FIRE RISK MANAGEMENT, INC

Memo Report

Subject: Independent Fire Protection Review for Cumberland County Civic Center Renovations

A review has been completed of the updated sets of fire protection construction documents (CD), which have been developed to support renovation efforts at the Cumberland County Civic Center in Portland, ME. The documents reviewed included both the fire protection demolition and design drawings (updated 4/12/13), along with the design specifications (updated 4/2/13) for the various fire protection and life safety related systems and the Building Code Report (dated 4/16/13).

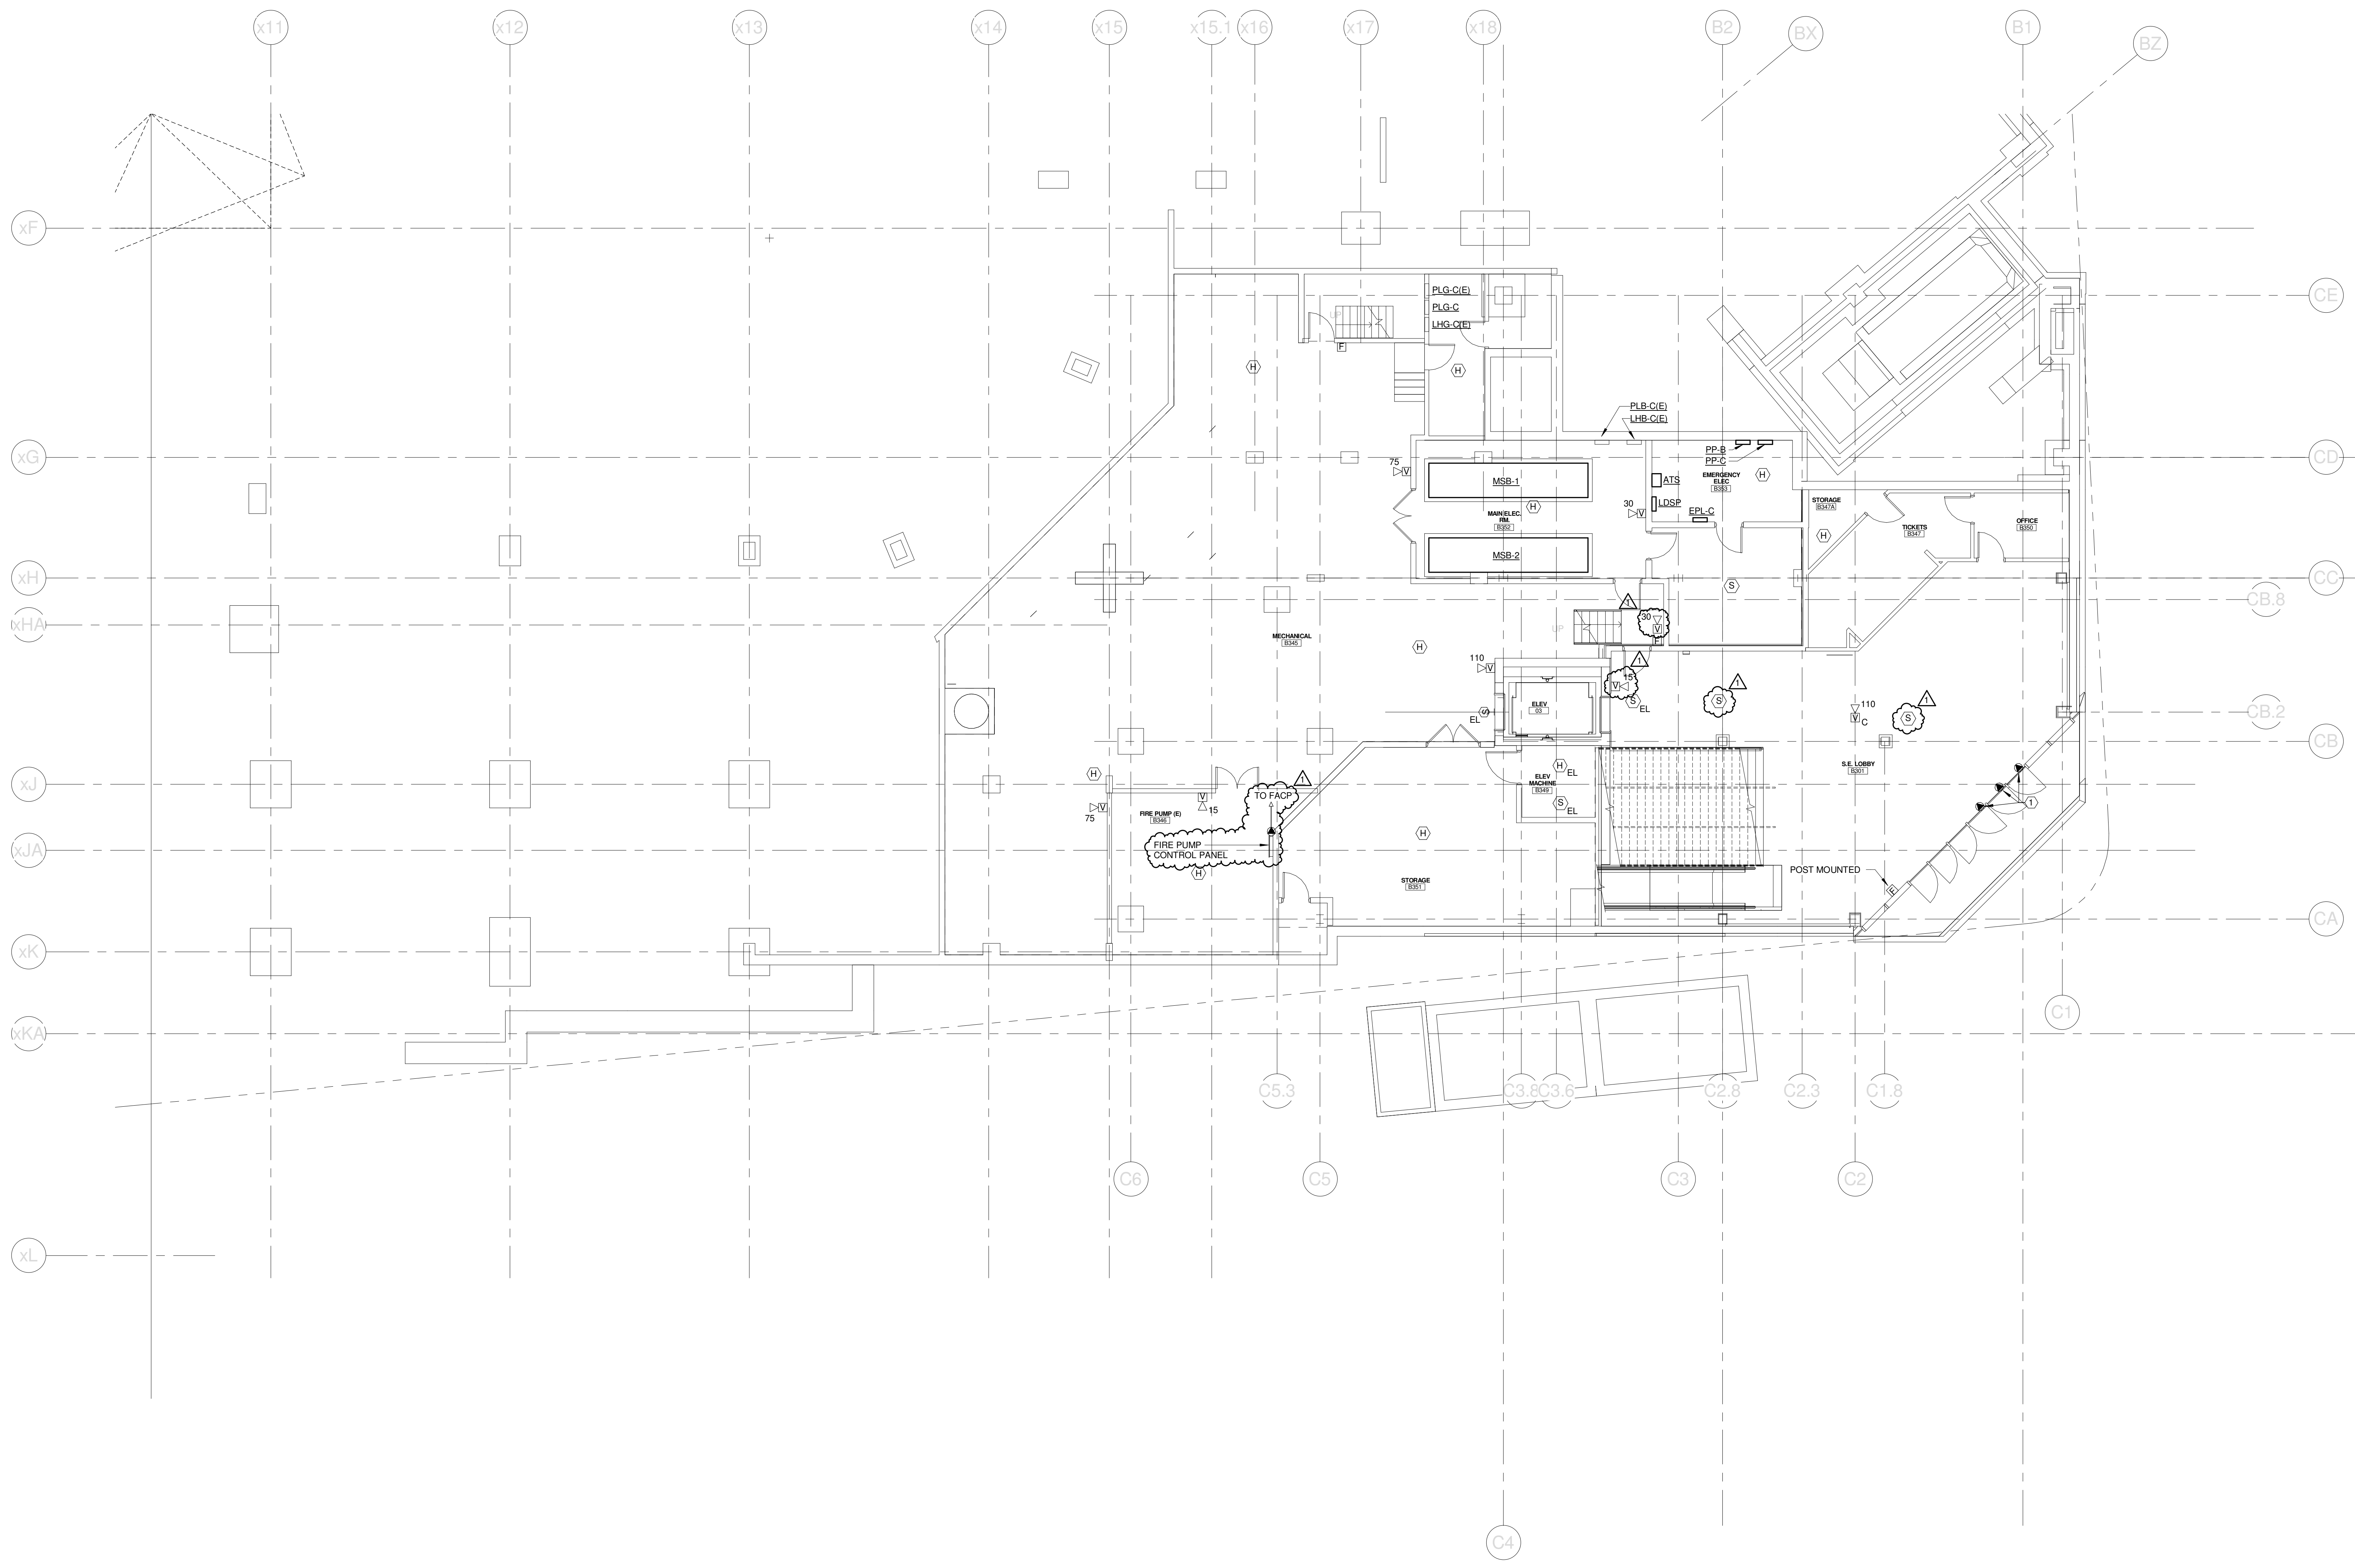
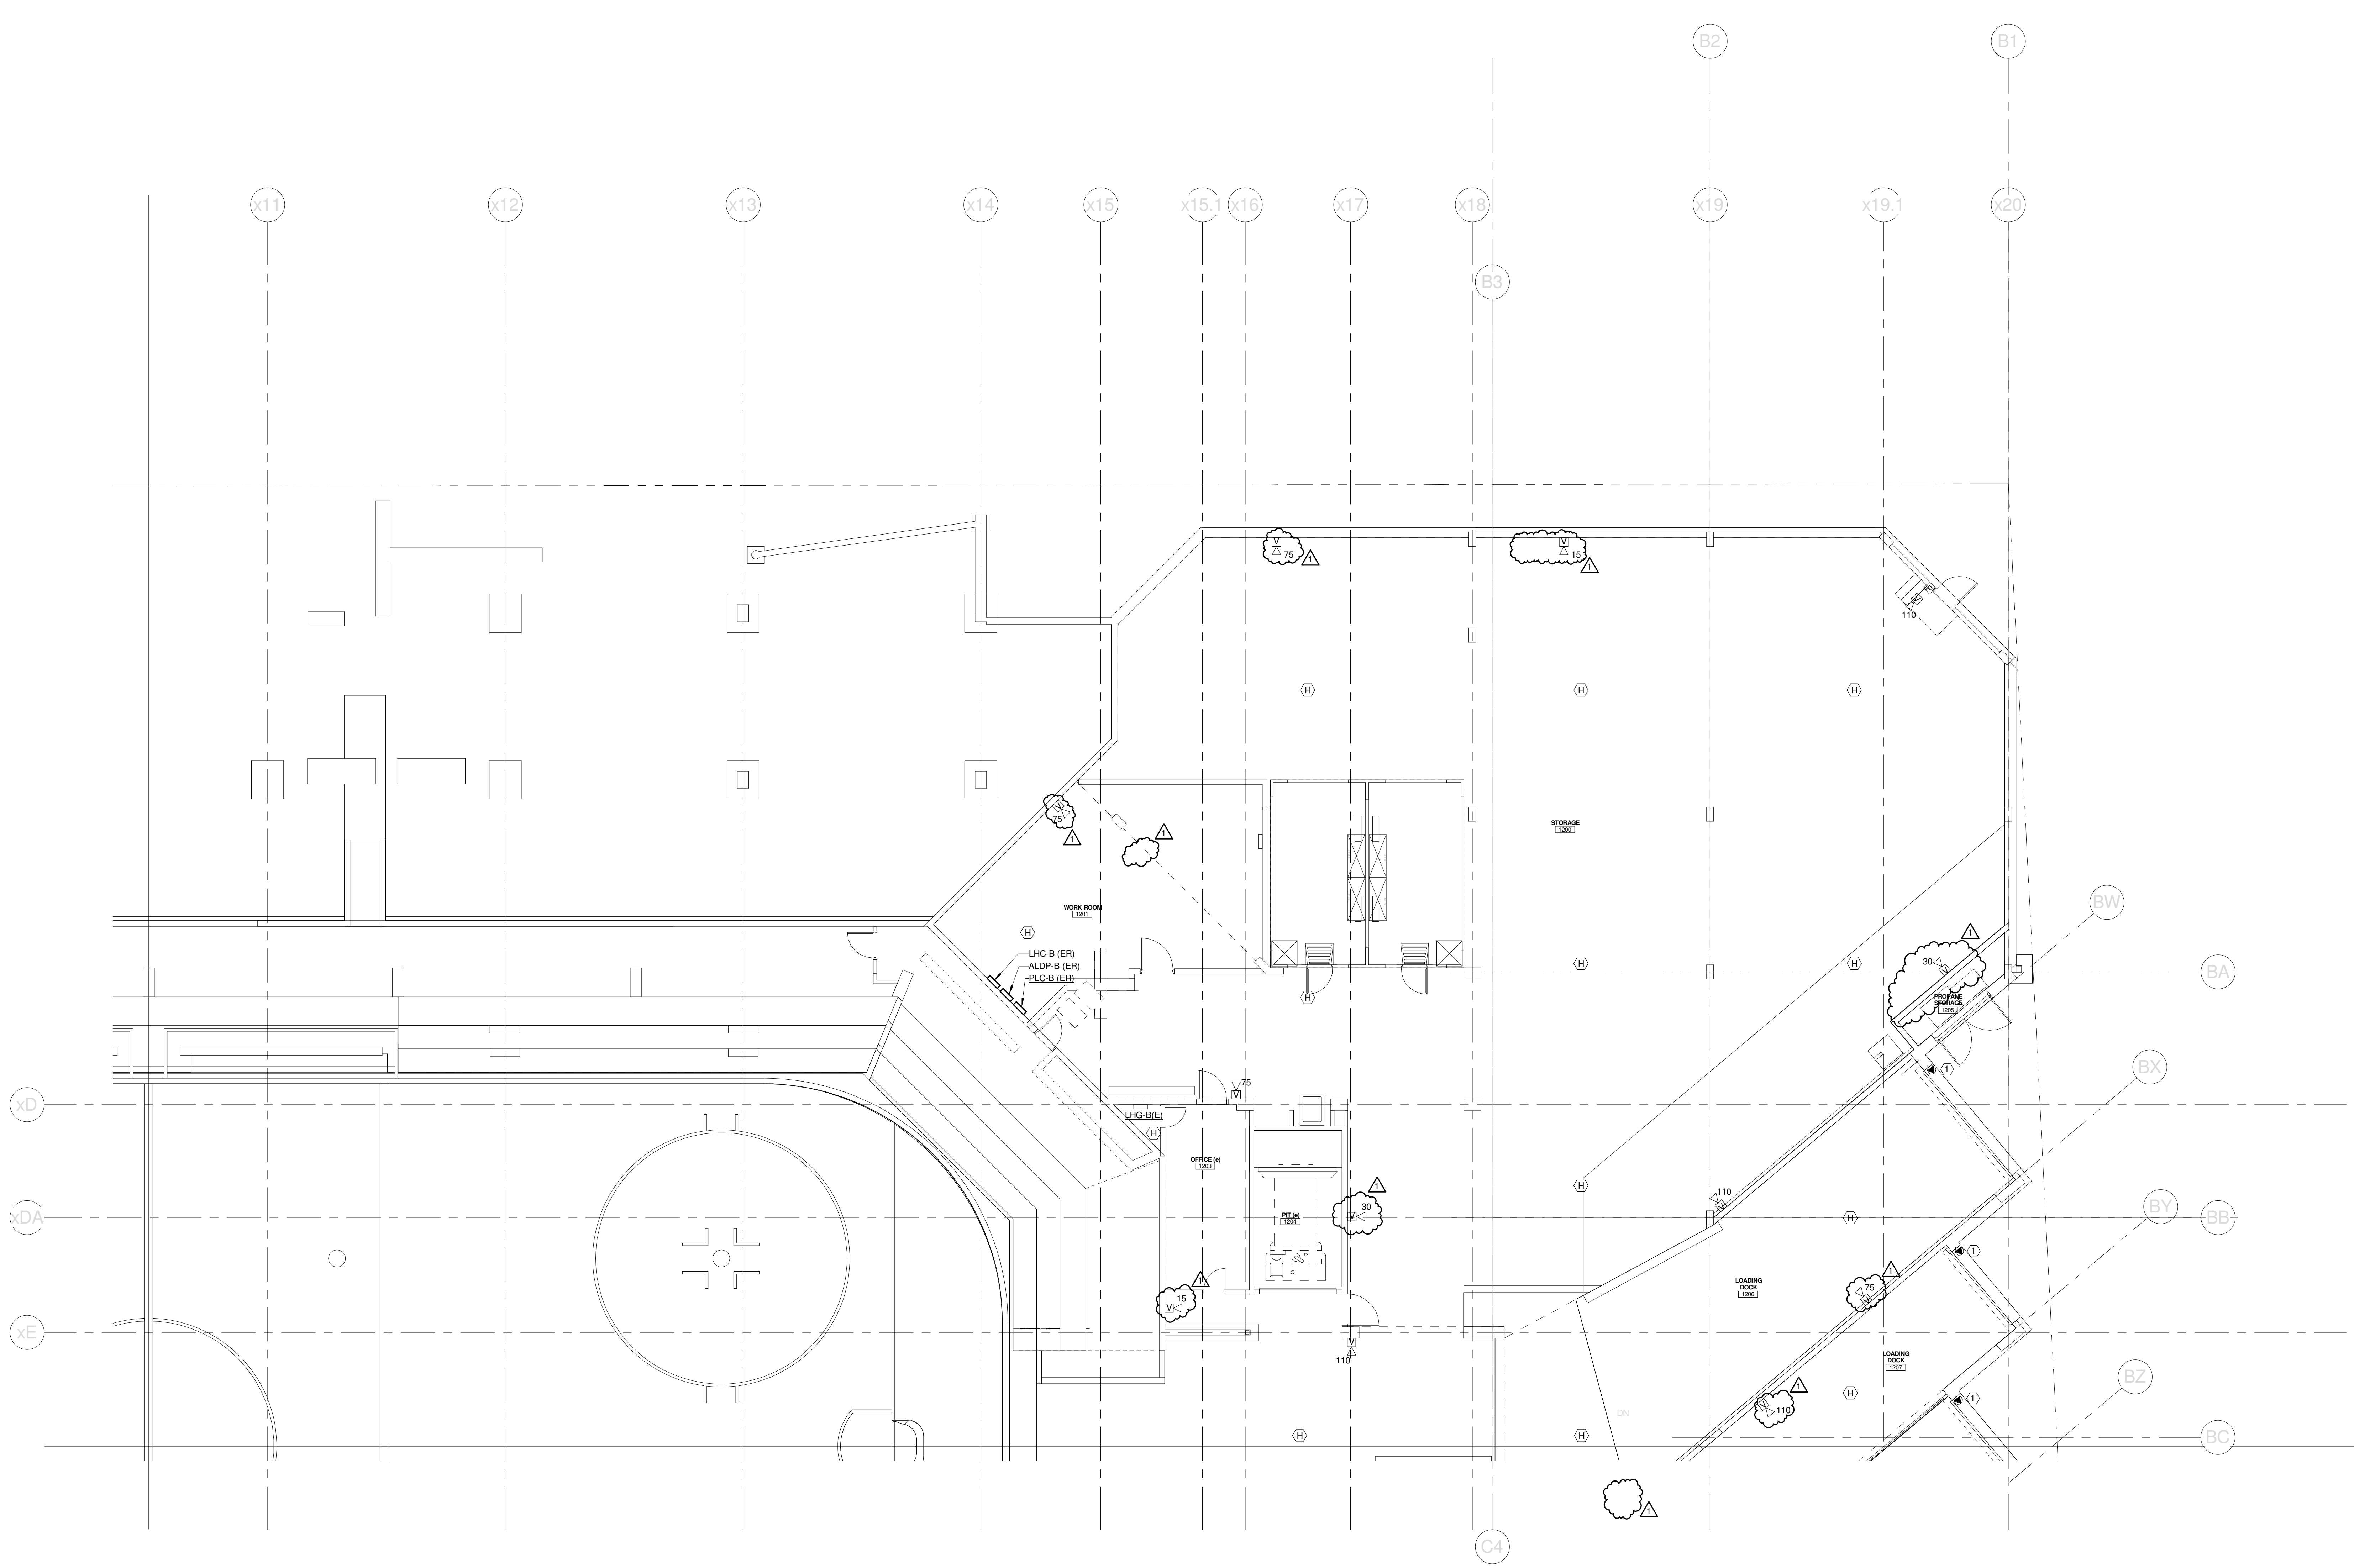
A detailed review of the Fire Alarm system drawings indicates that a number of questions and concerns still exist. Specifically, this includes the many heat detectors that are installed throughout the various spaces within the facility. These devices are unnecessary, given that this facility is fully protected by automatic sprinkler systems, and will represent not only a notable capital cost, but also a significant life cycle cost to the City of Portland. The inclusion of these devices, along with a number of smoke detectors that are not required (such as in corridors of office areas in NW mezzanine), should be verified with the client to ensure they understand and agree with this approach. These devices will provide very little benefit to the overall life safety and fire protection of this facility.

It is recommended that the plans for locating notification devices be reviewed. Specifically, this involves areas that do not require the installation of visual devices, but must still comply with the audibility requirements. Given the locations of the planned notification devices as depicted on the drawings, consideration should be given to the addition of speakers within some of the other non-public spaces that are either relatively large or located such that the sound from the closest speakers may be insufficient to achieve code compliance. It is unknown if any prior sound measurements have been taken to establish “ambient” noise levels throughout the facility, but if not, a contingency plan should be developed to provide an allowance for additional speakers to be provided in areas that may demonstrate insufficient audibility levels during preliminary system testing. Currently, the system specifications do not require the installing contractor to perform such an evaluation prior to the installation of the system to verify device locations.

Based on this recent review, questions regarding the code compliance of the locations of notification devices exist for several areas, including; the Staging and Marshaling and First Aid areas at the west and east ends, respectively, of the Event Level, along with the general plan for notification within the Seating Bowl area. The specific floor to ceiling height within the Bowl area is not specifically depicted on the drawings, but it is believed that this exceeds the 30-foot maximum that is outlined in NFPA 72 for ceiling mounted devices. The only notification devices for the Bowl area are shown on the “Catwalk Level” plan. It is believed that the current plan for notification in the Bowl area would not be considered code compliant; especially as it pertains to the numbers and locations of devices that are installed to support this area.

Although notes exist on drawings identifying the beam type smoke detectors, these devices should also be identified within the legend for the drawings.
